Recommendation Report for Listed Building Consent for Alterations, Extension or Demolition**REF NO:** R/57/12/L**LOCATION:** Old Orchard House
47 The Street
Rustington**PROPOSAL:** Application for Listed Building Consent for extension and conversion of existing garage to form a separate studio. Resubmission following R/238/11/L.**SITE AND SURROUNDINGS**

DRW NO 4 SCALE 1/50
PROPOSED ROOF PLAN

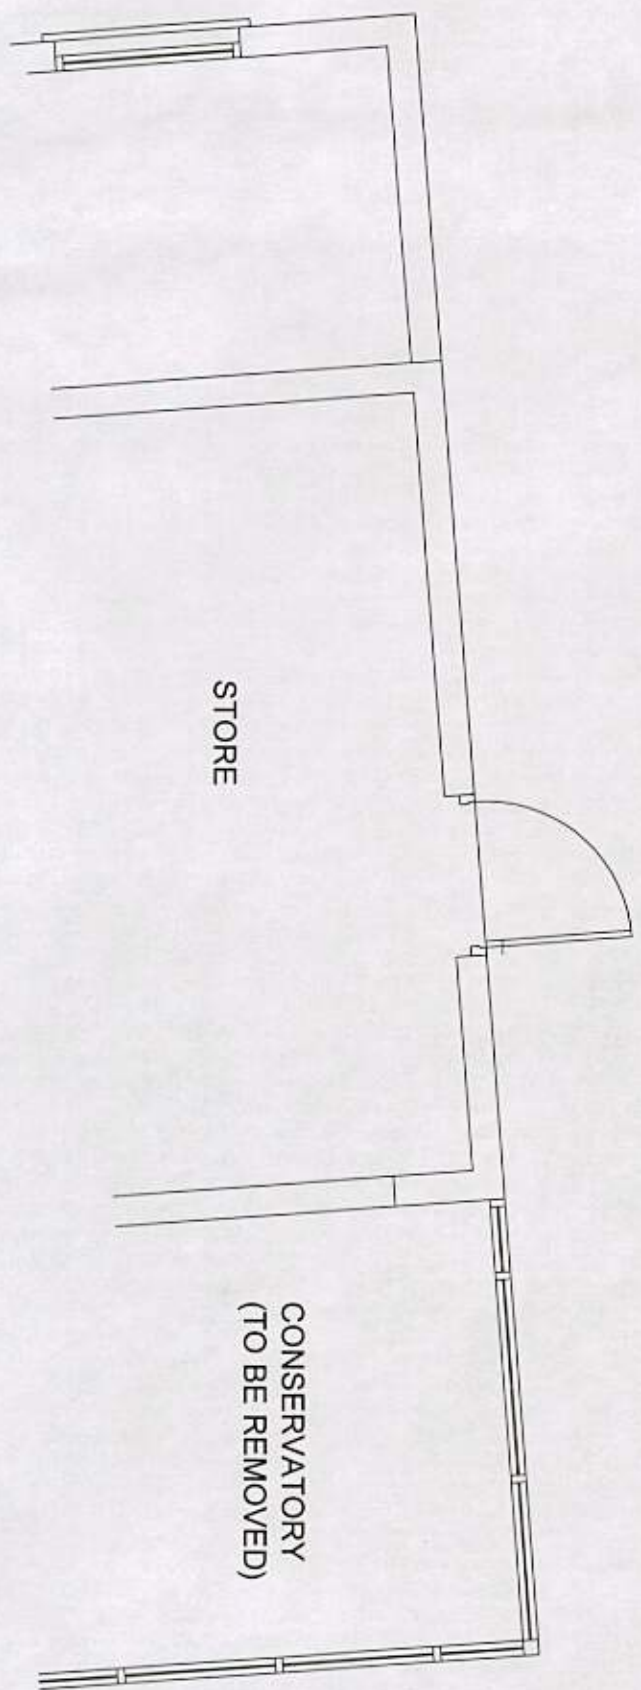
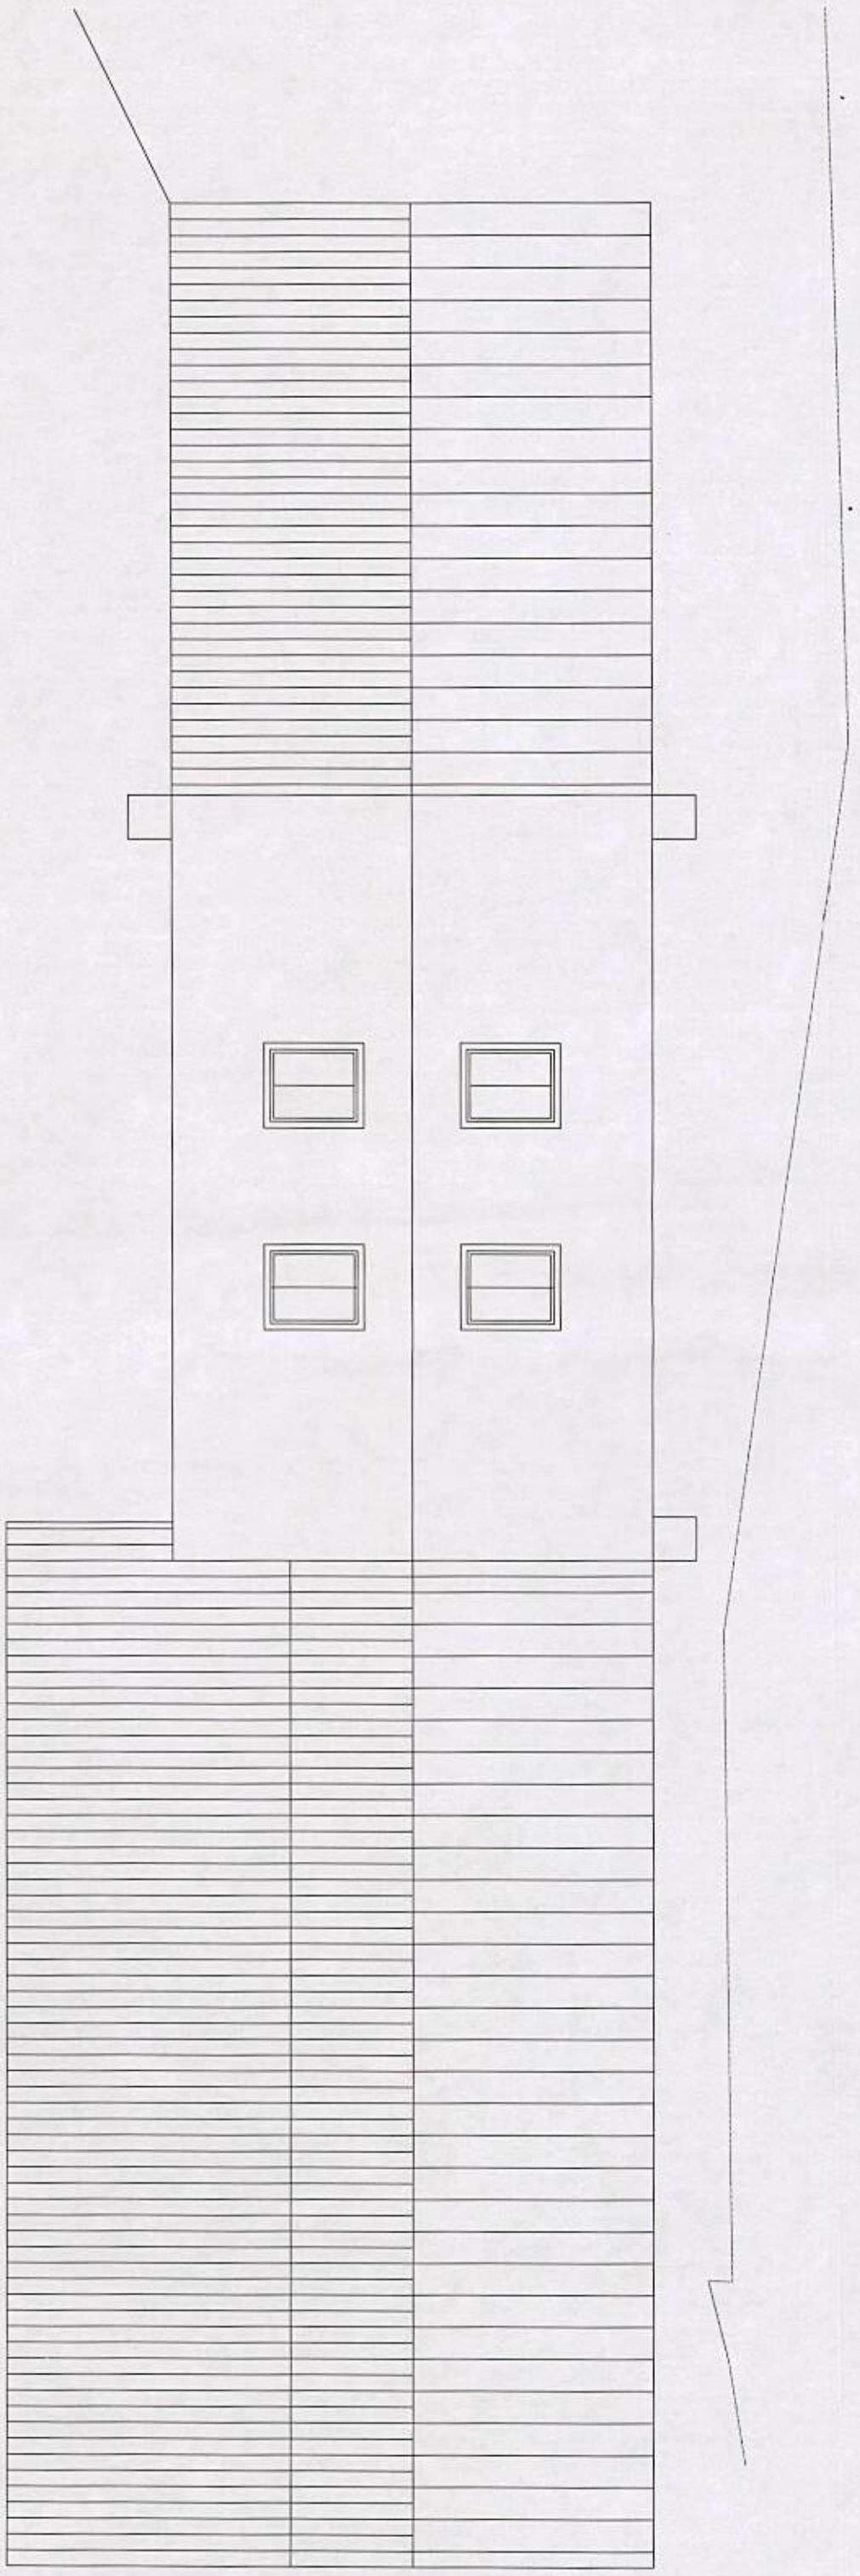
The application seeks listed building consent for the conversion and extension of an existing outbuilding as well as demolition of a section of a covered store area and part of the conservatory to the rear of the adjacent outbuilding. Also proposed is a pitched roof to replace the existing flat roof above the garage forward of the outbuilding proposed to be converted.

DRW NO 5 SCALE 1/50
ELEVATIONS

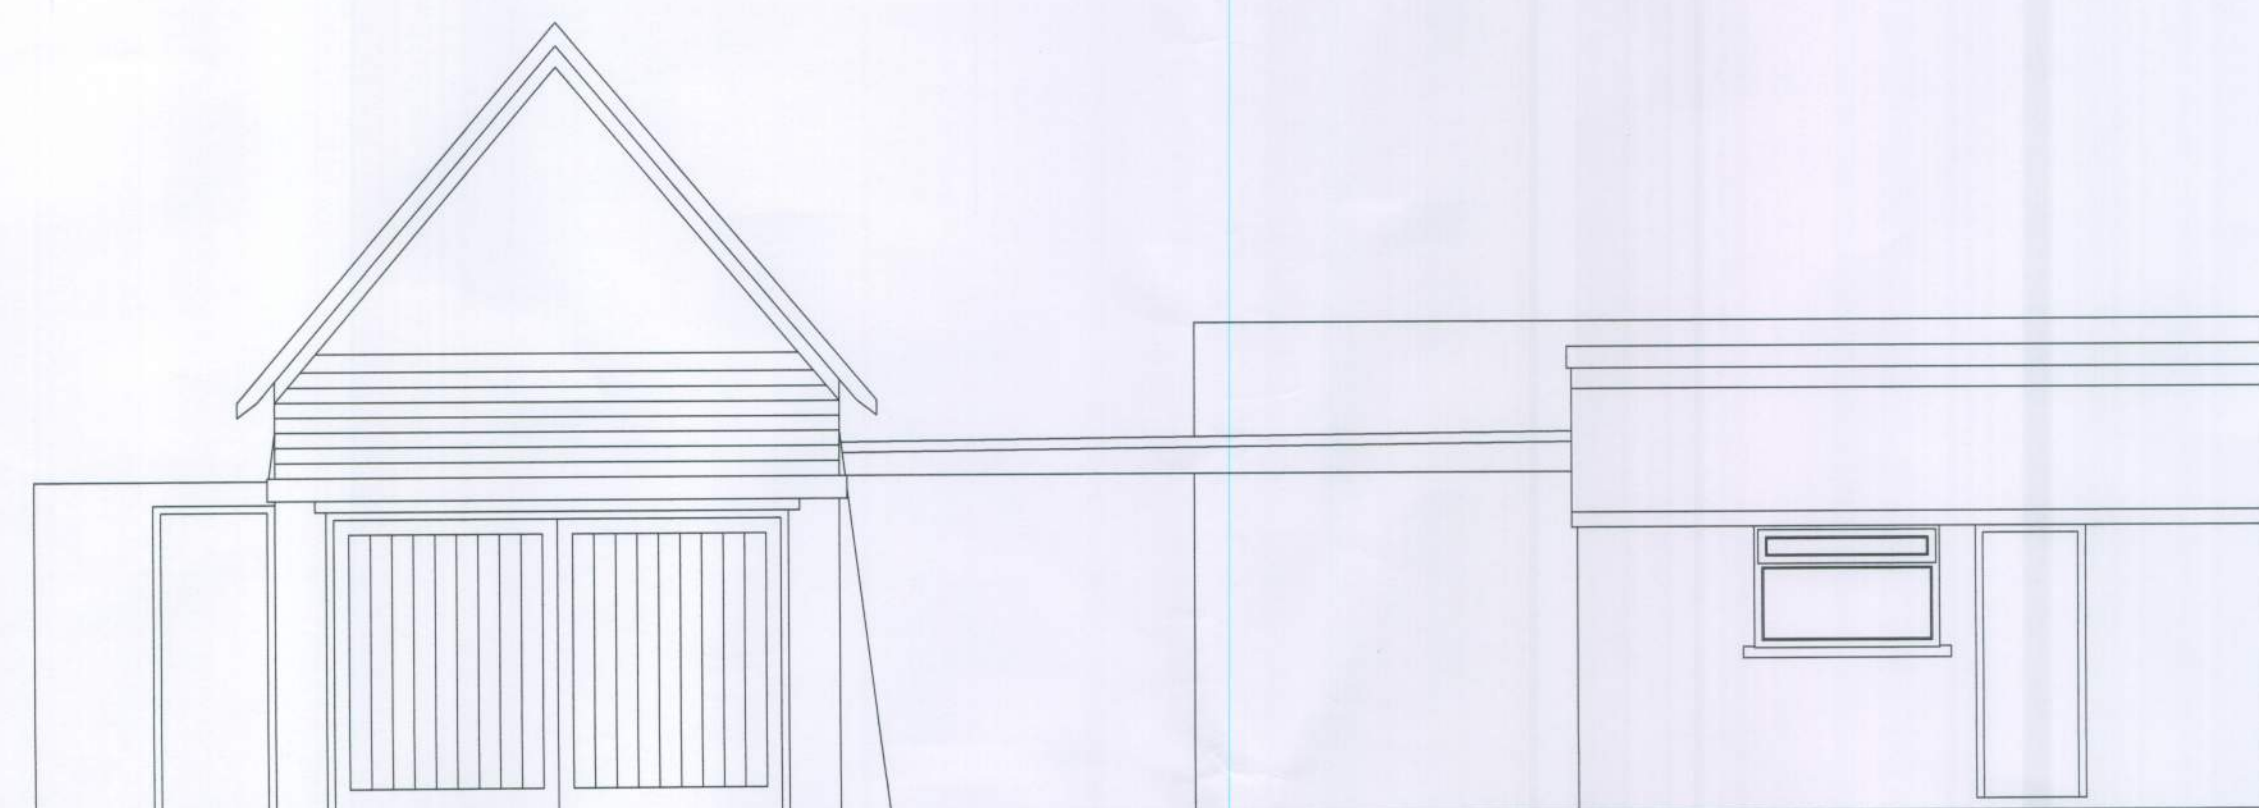
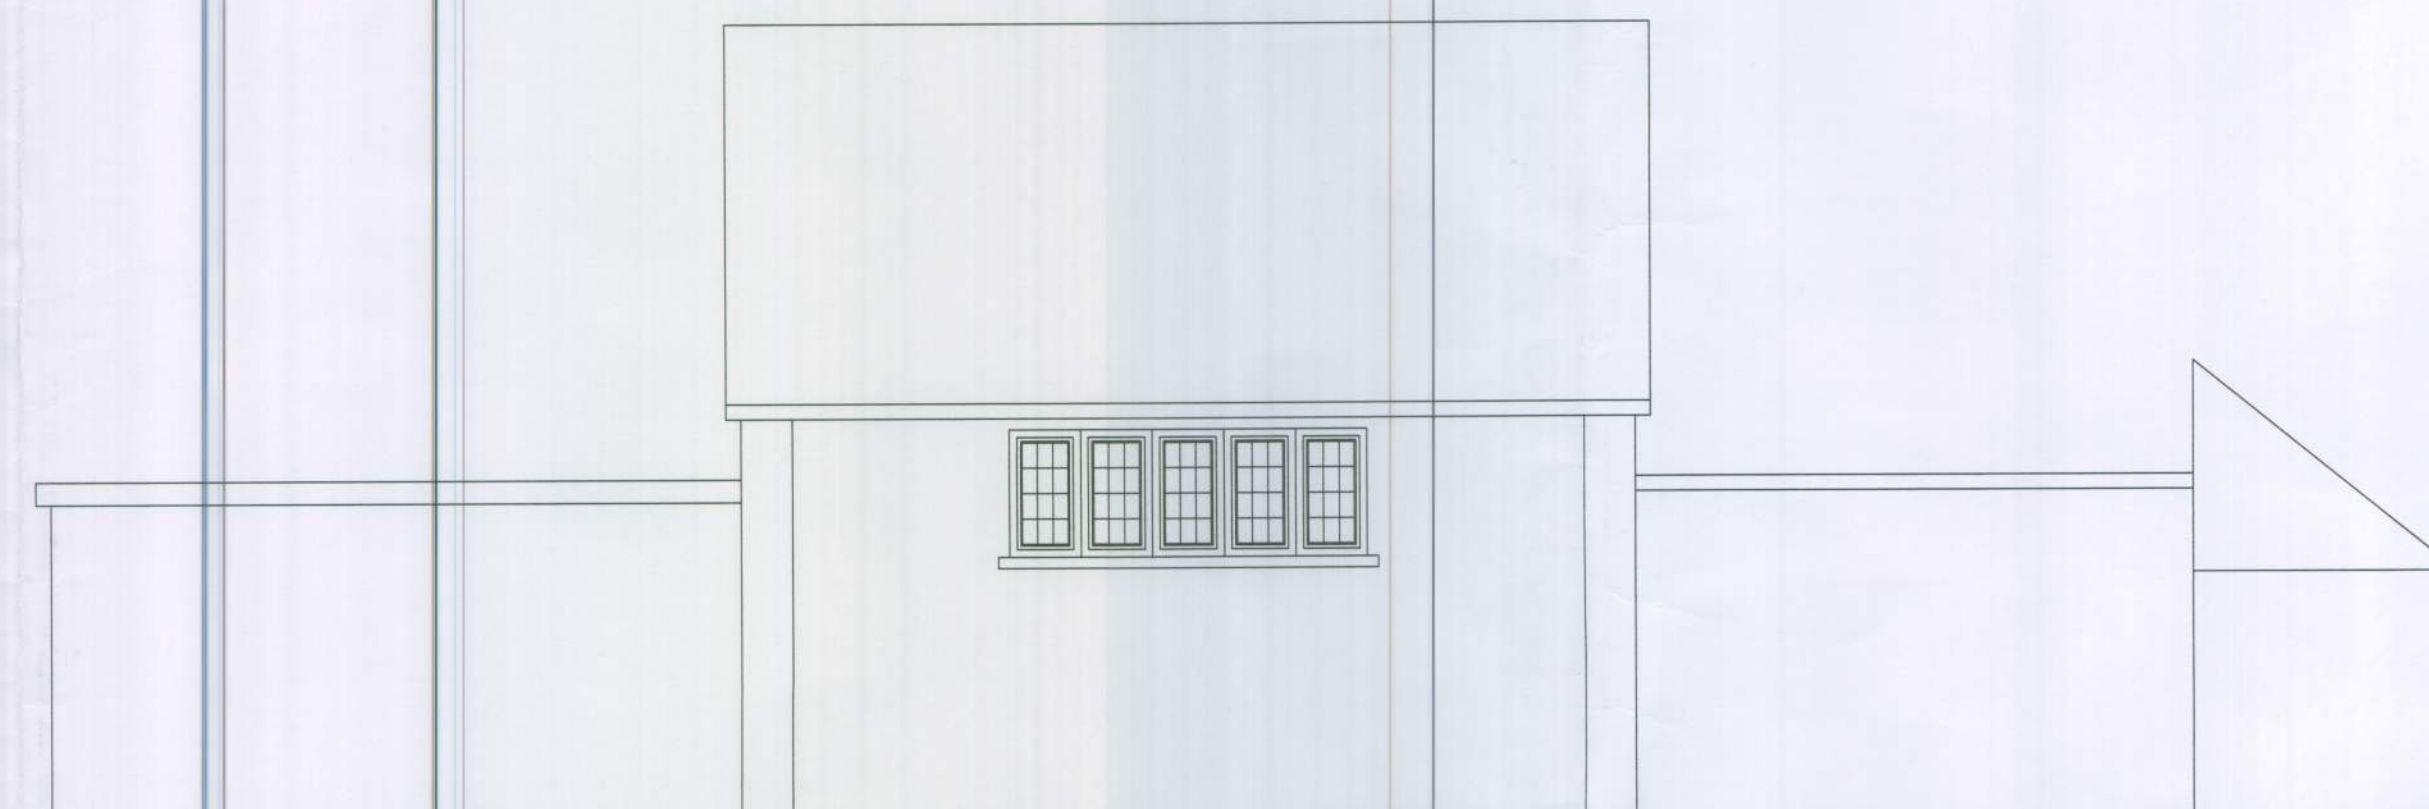
The introduction of the pitch roof over the garage is considered to improve the appearance of the outbuilding from the street scene, with the roof pitch reflecting that of the large outbuilding from which it extends and the use of materials will ensure visual integration and sympathy towards the listed building. Similarly, the rear addition will continue the roof pitch of the outbuilding continuing the simple roofscape with the introduction of roof lights within the east and west elevations. To ensure that the additions are sympathetic to the setting of the historic asset, the materials used for the construction of the building will be subject to a conditional approval.
